**ADC Planning Consultation
Conservation/Design Officer Response**

Application Number	AB/26/18/L
Address	The Swan Hotel 27-29 High Street Arundel BN18 9AG
Description	Listed building Consent for replacement of the existing external signage scheme
Case Officer	<u>Mr A Wood</u>
Date	3 rd April 2018

The Swan Hotel is Grade II Listed and within Arundel Conservation Area

Sign A1 -
1 No. signwritten house name to front elevation
with two LED floodlights.
Size: 1400mm wide
Scale: 1:20

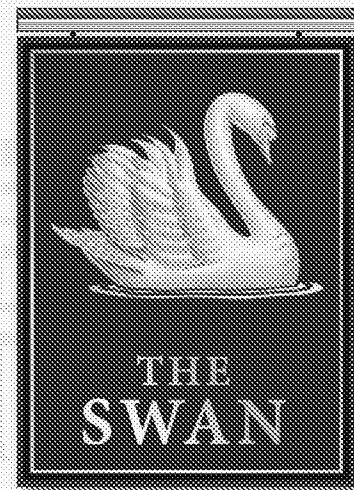
The other proposed painted signs 'The Swan' and 'Fullers' signs should be applied to the buildings face so as not to compete with the natural horizontal reading of the elevations. This may be achieved by reducing the size of the painted lettering so that they are accommodated between window head and cill level. Otherwise, these signs are considered suitable.

Sign C -
1No. Pictorial sign fixed to existig bracket
Size: 900mm x 1200mm
Scale: 1:20

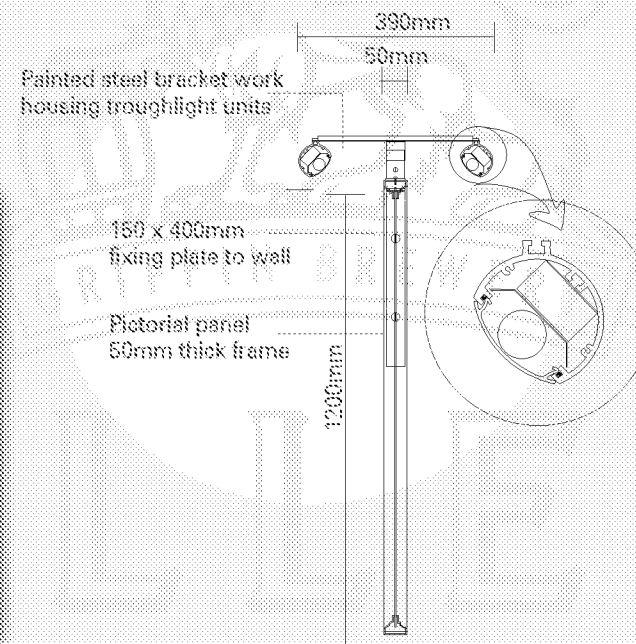
The proposal is also to replace the existing, traditional hanging sign with a roundel set in unspecified metalwork, using existing hanging bracket. Public House/Inn signage has a long history, and is traditionally a painted board. It is recommended that the replacement sign continues this (or the present sign retained), and that the proposed is considered unsympathetic and be recommended for refusal.

Sign E -
2No. Brass
Menu holder.
Size: A3
Scale: 1:10

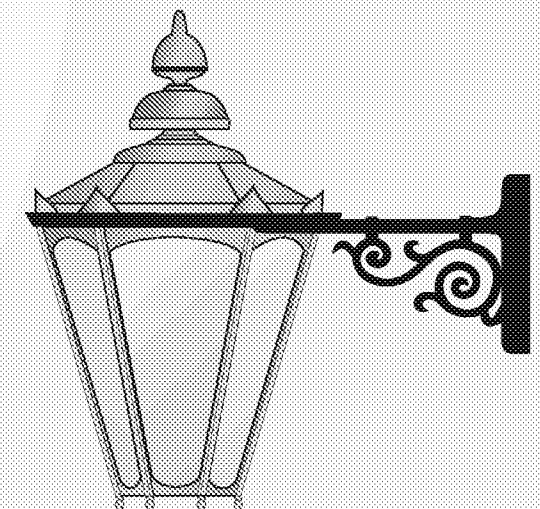
The menu board is considered suitable and it is recommend that it be approved.
